Addendum No. 1

RE: Contract ID C203409

Jackson County (B-4554)

Bridge #145 Over SR-1705, Southern Railroad and Scott Creek

REVISIONS						SHEET NO.
NO.	BY:	DATE:	NO.	BY:	DATE:	TOTAL SHEETS
1			3			S-6
2			4			61

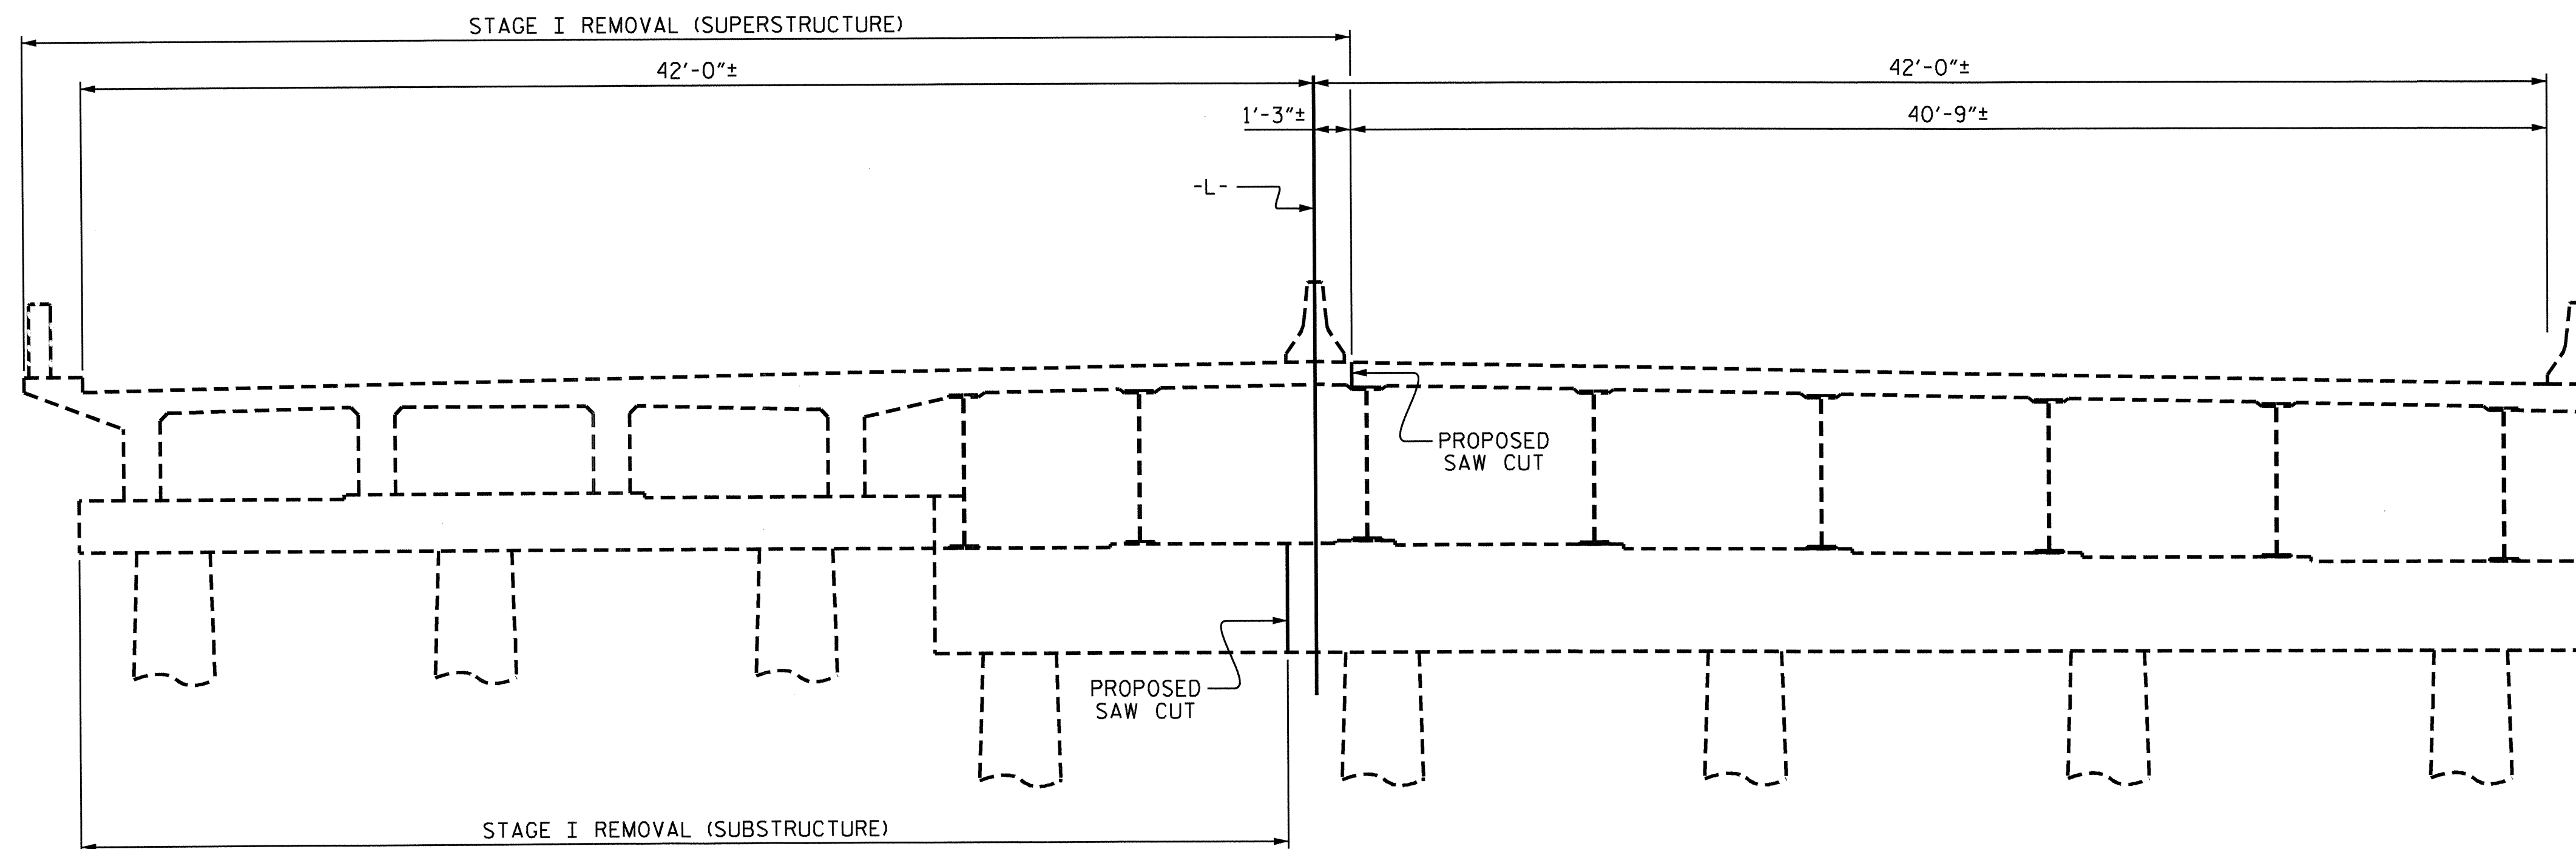
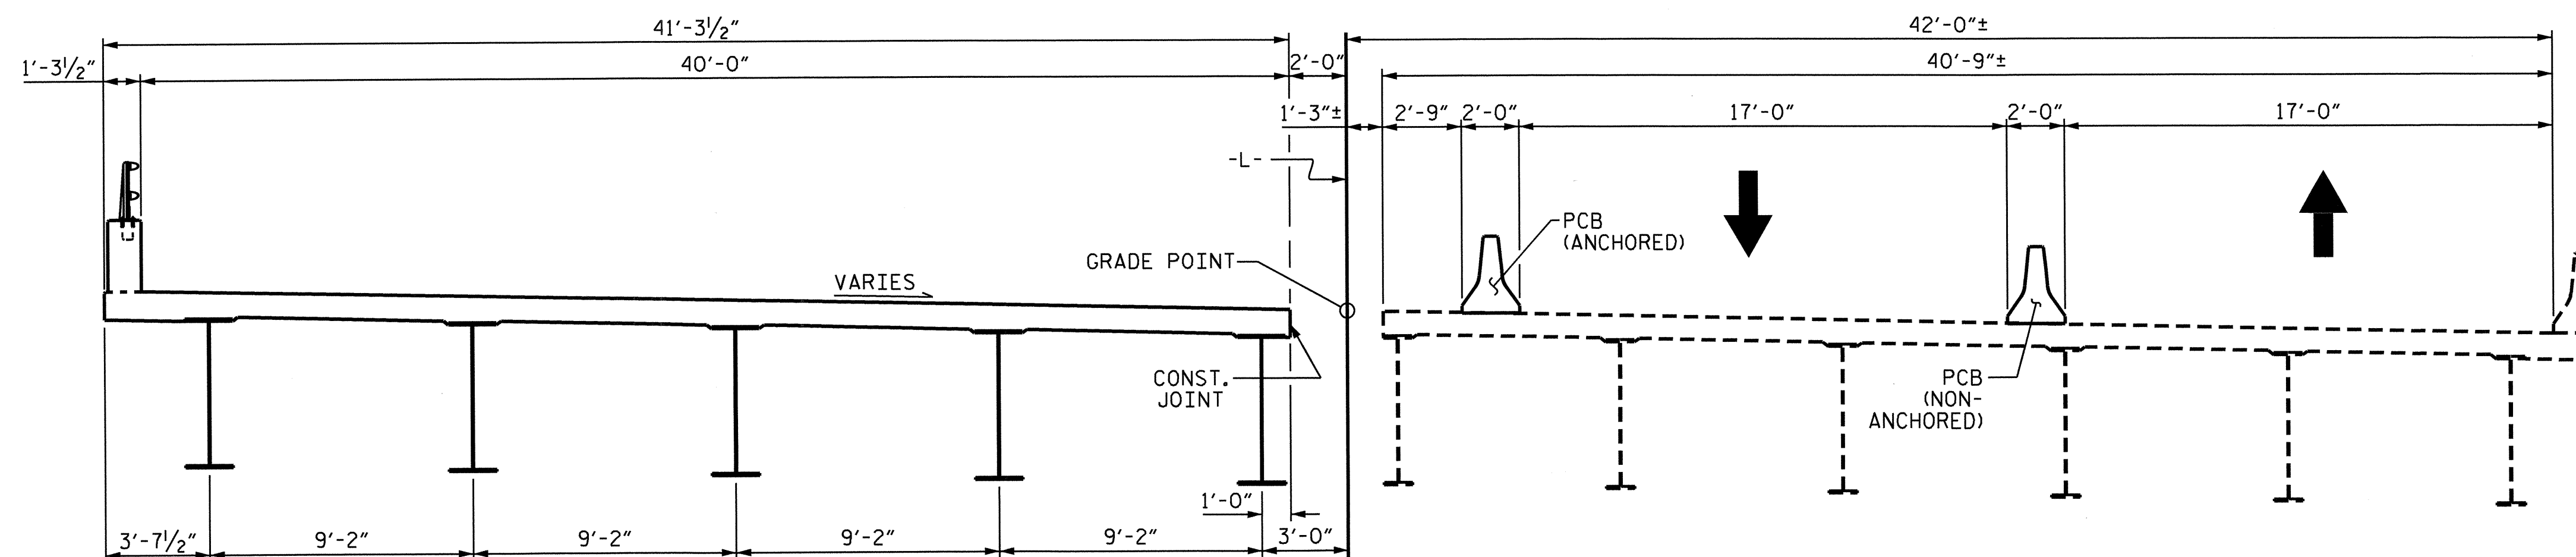
On Sheet No. S-6 some changes have been made to the Construction Sequence details and notes. Please void Sheet No. S-6 in your plans and staple the revised Sheet No. S-6 thereto.
